jb planning associates

Our Ref: PA/1040/sf
Your Ref: S6/2011/1994/MA

Salisbury Square, Old Hatfield, Herts

Re: Salisbury Square, Old Hatfield, Hertfordshire – Planning Application S6/2011/1994/MA

DRAWING NUMBER:
789-112 C

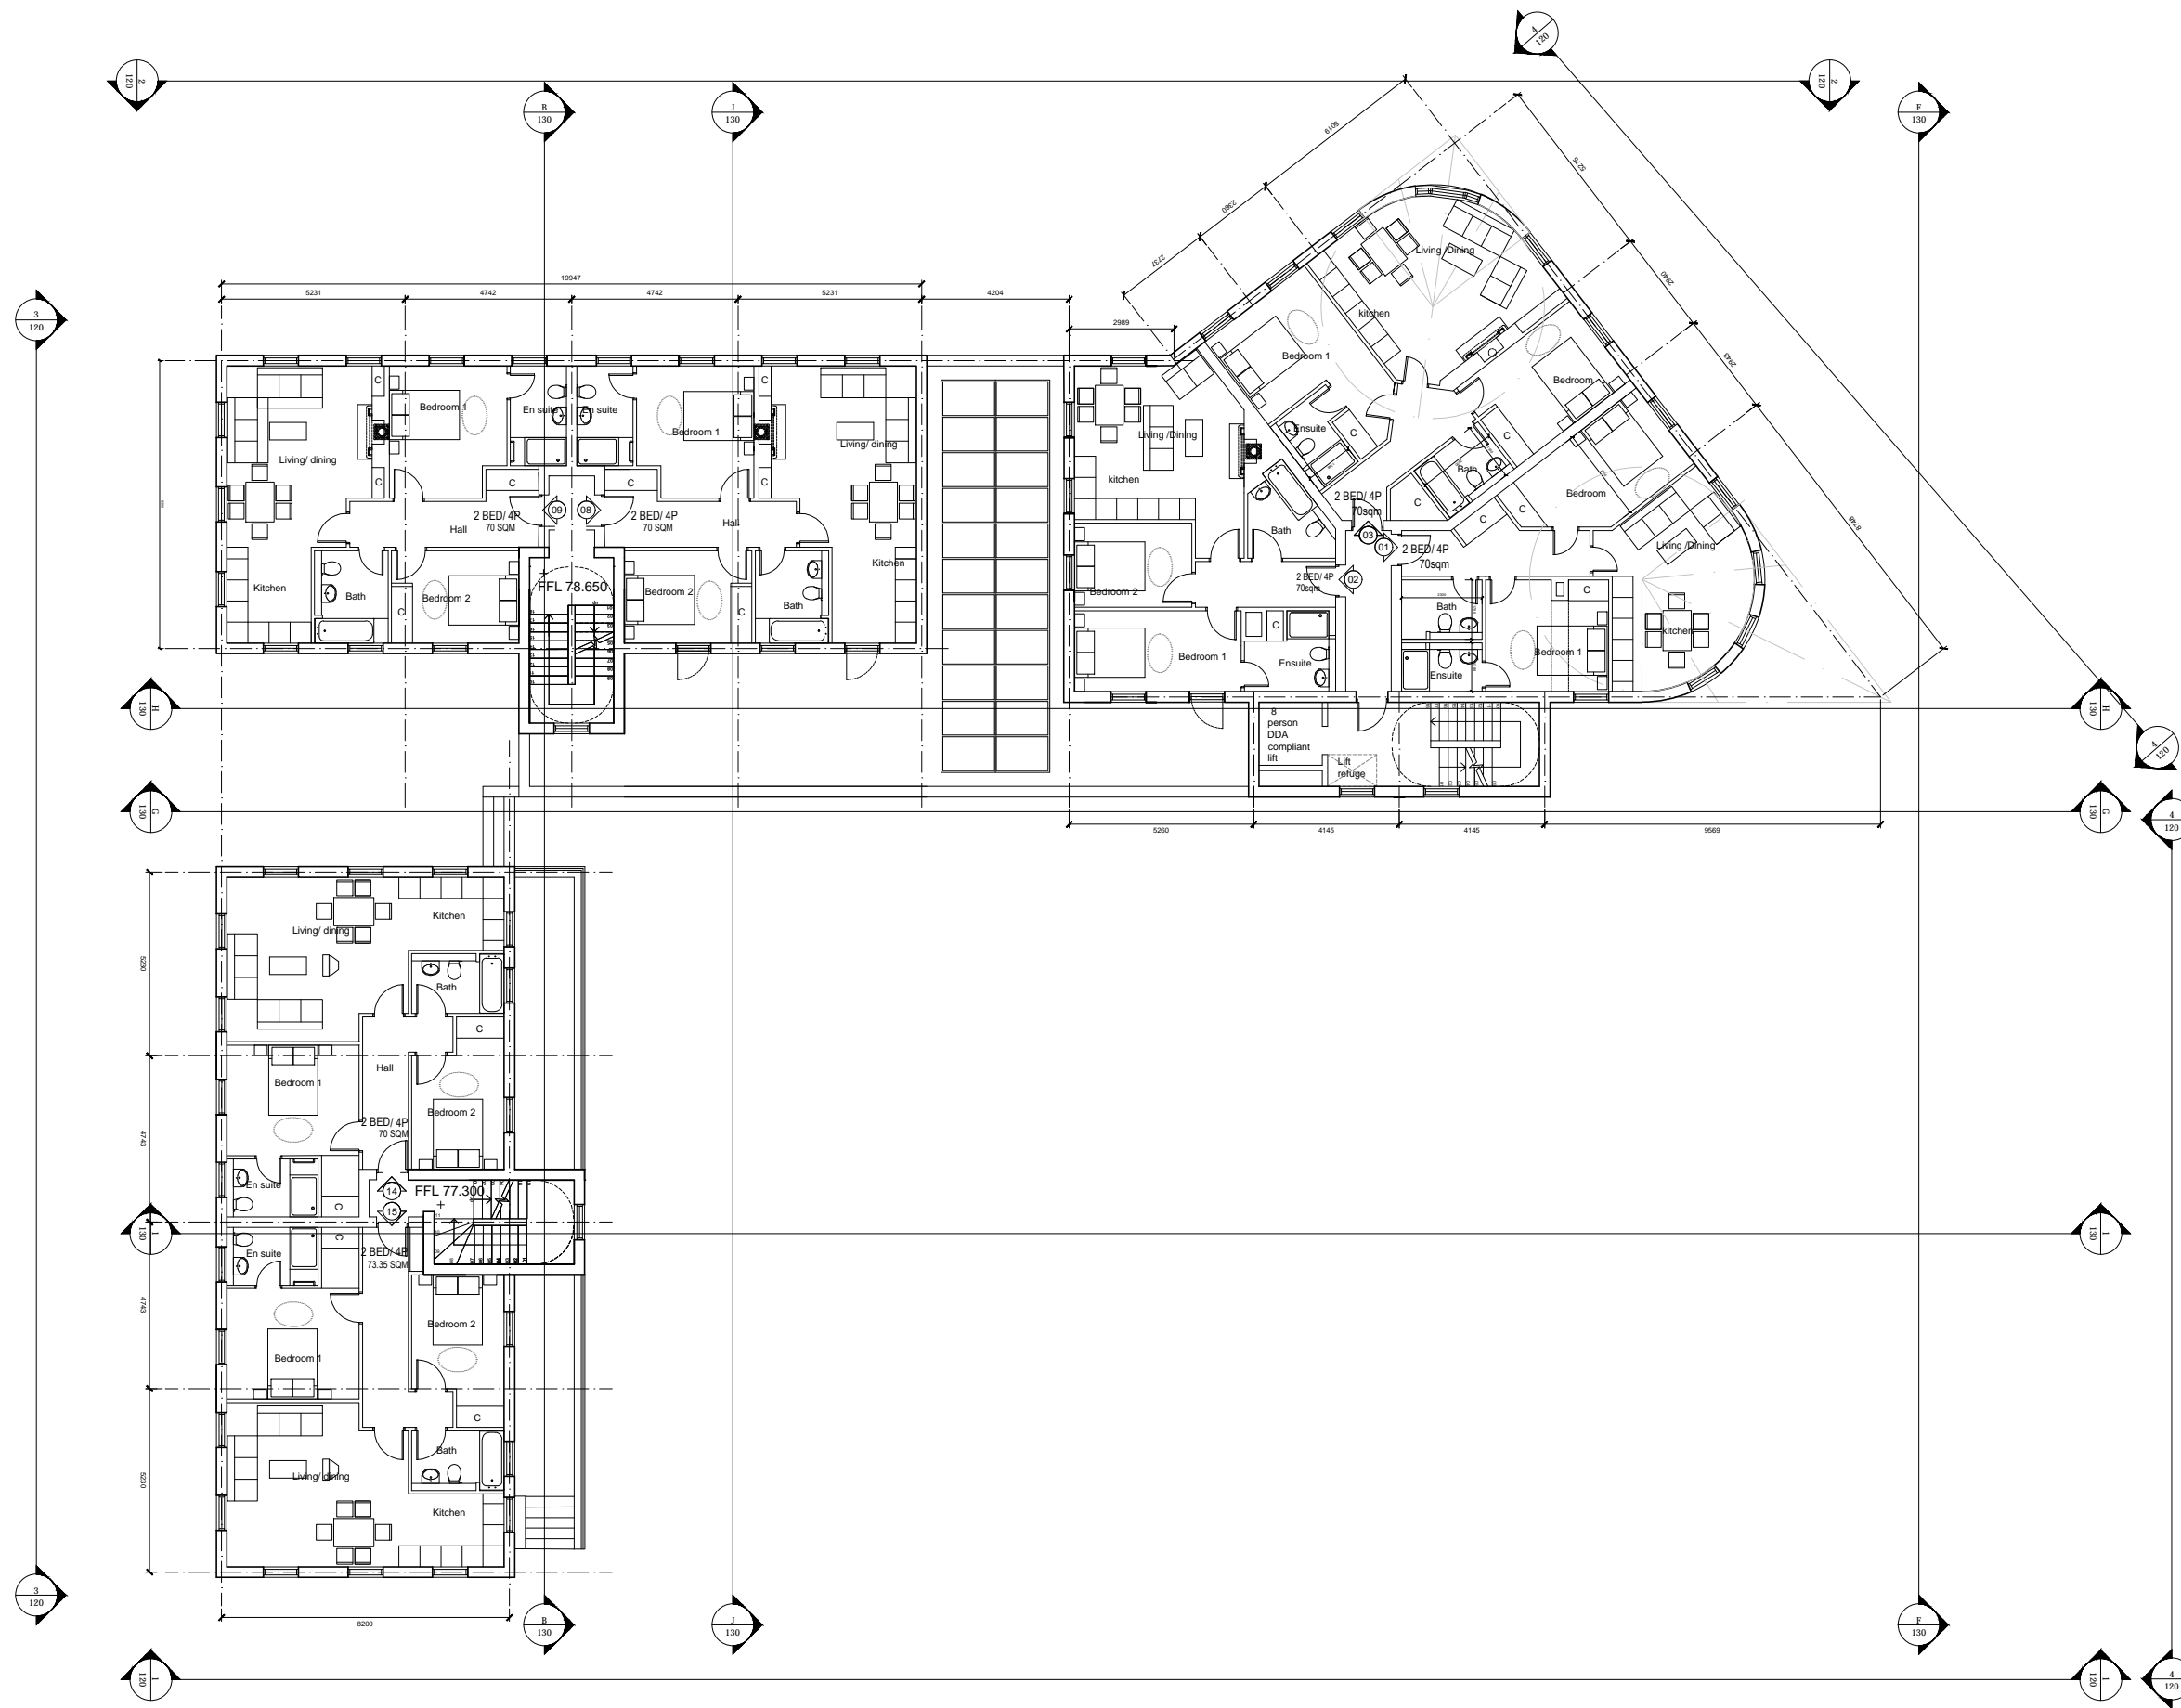
1. **Missing 2-bed unit** – We believe the discrepancy has occurred on drawing number 789-112 C - there are seven two-bedroom flats shown, (there are three in the block above commercial unit D).

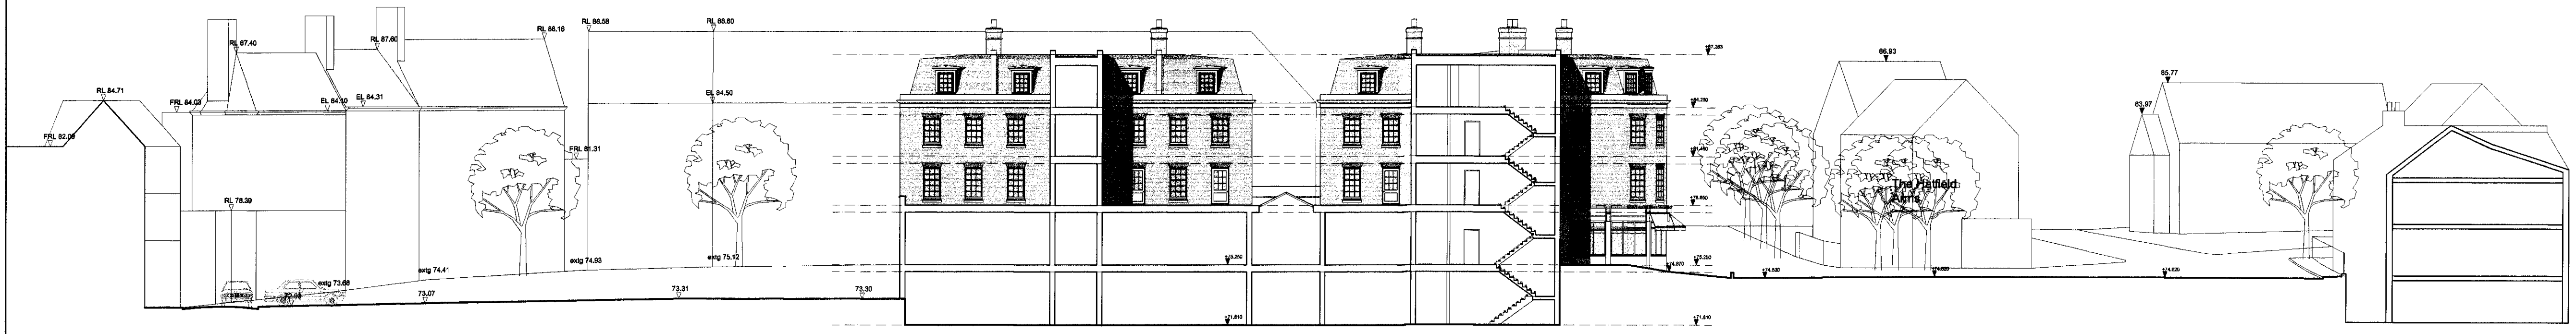
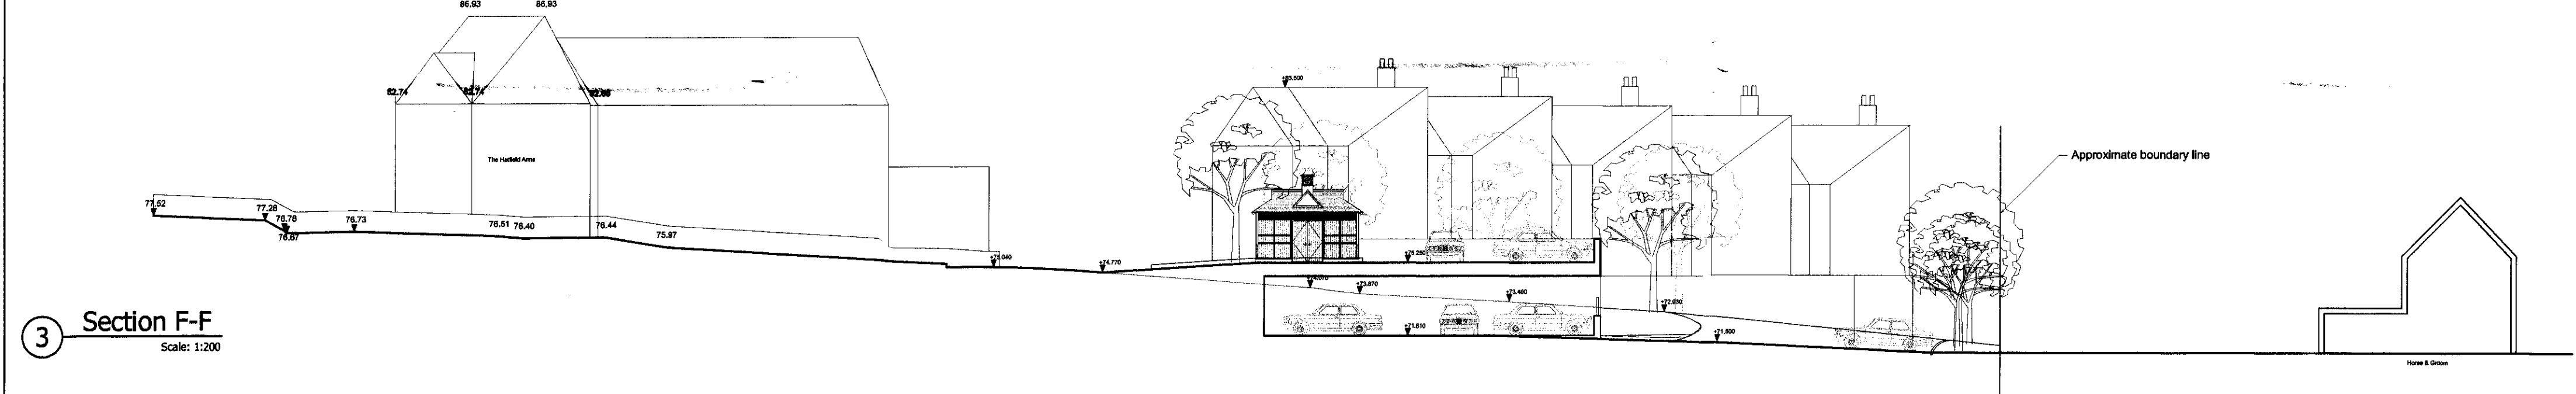
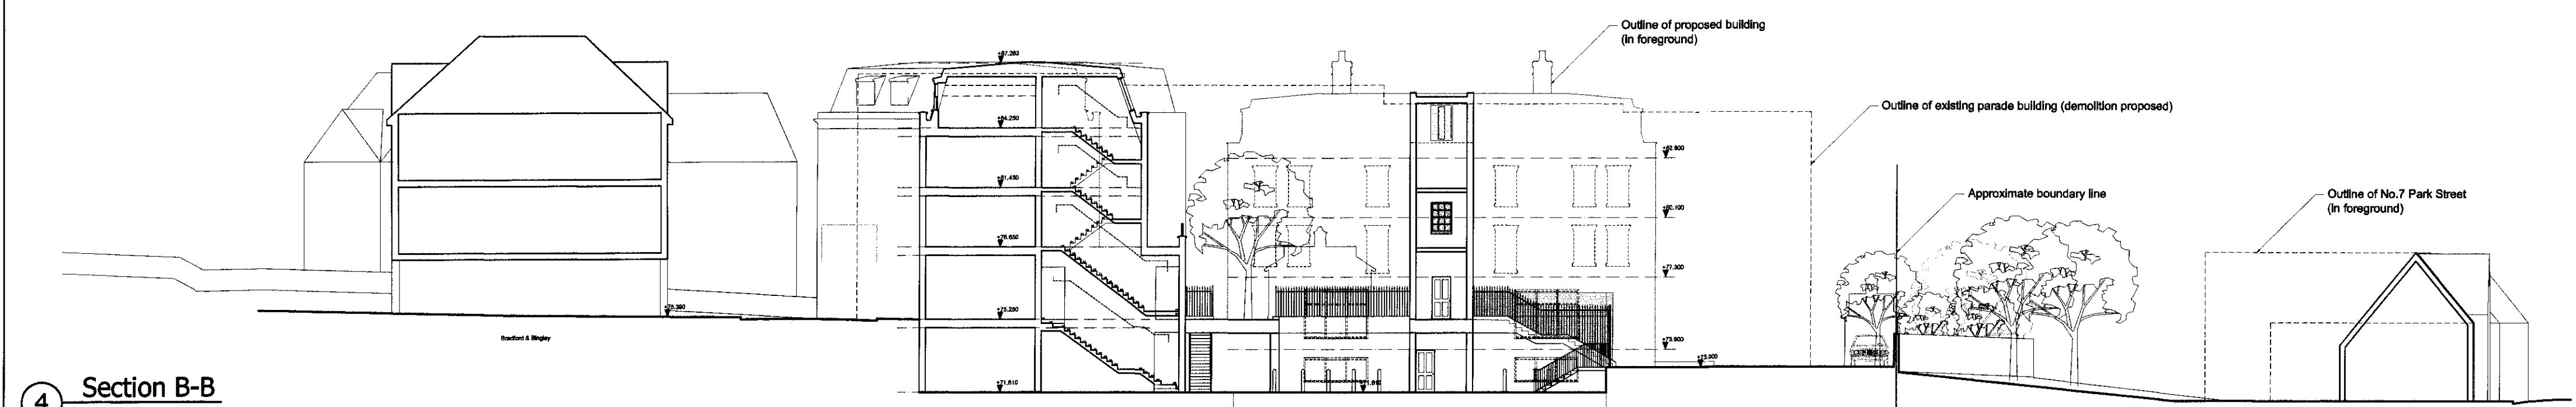
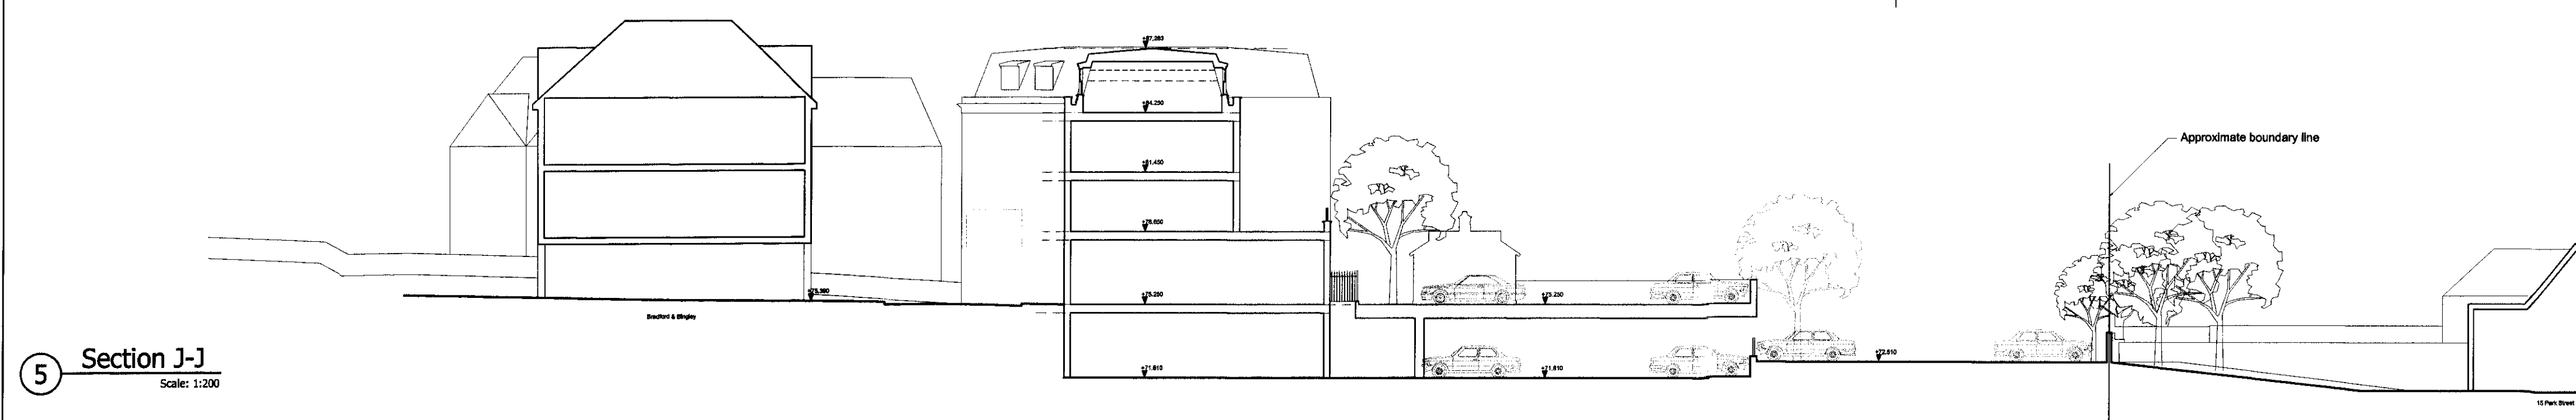
'Park Street will be overshadowed by the new car park'

The applicants have updated the architectural sections (please see Drawing 789-130E) showing the relationship between the existing and the new buildings. This shows that the height of the car park is comparable to the existing car park which is on rising ground and partly enclosed by a series of retaining walls and landscaped planting beds. The new car park utilises the natural slope of the land and the lower deck is achieved through excavation rather than an overall increase in height. There is a reasonable degree of separation between the properties in Park Street and the new buildings which as you are aware are
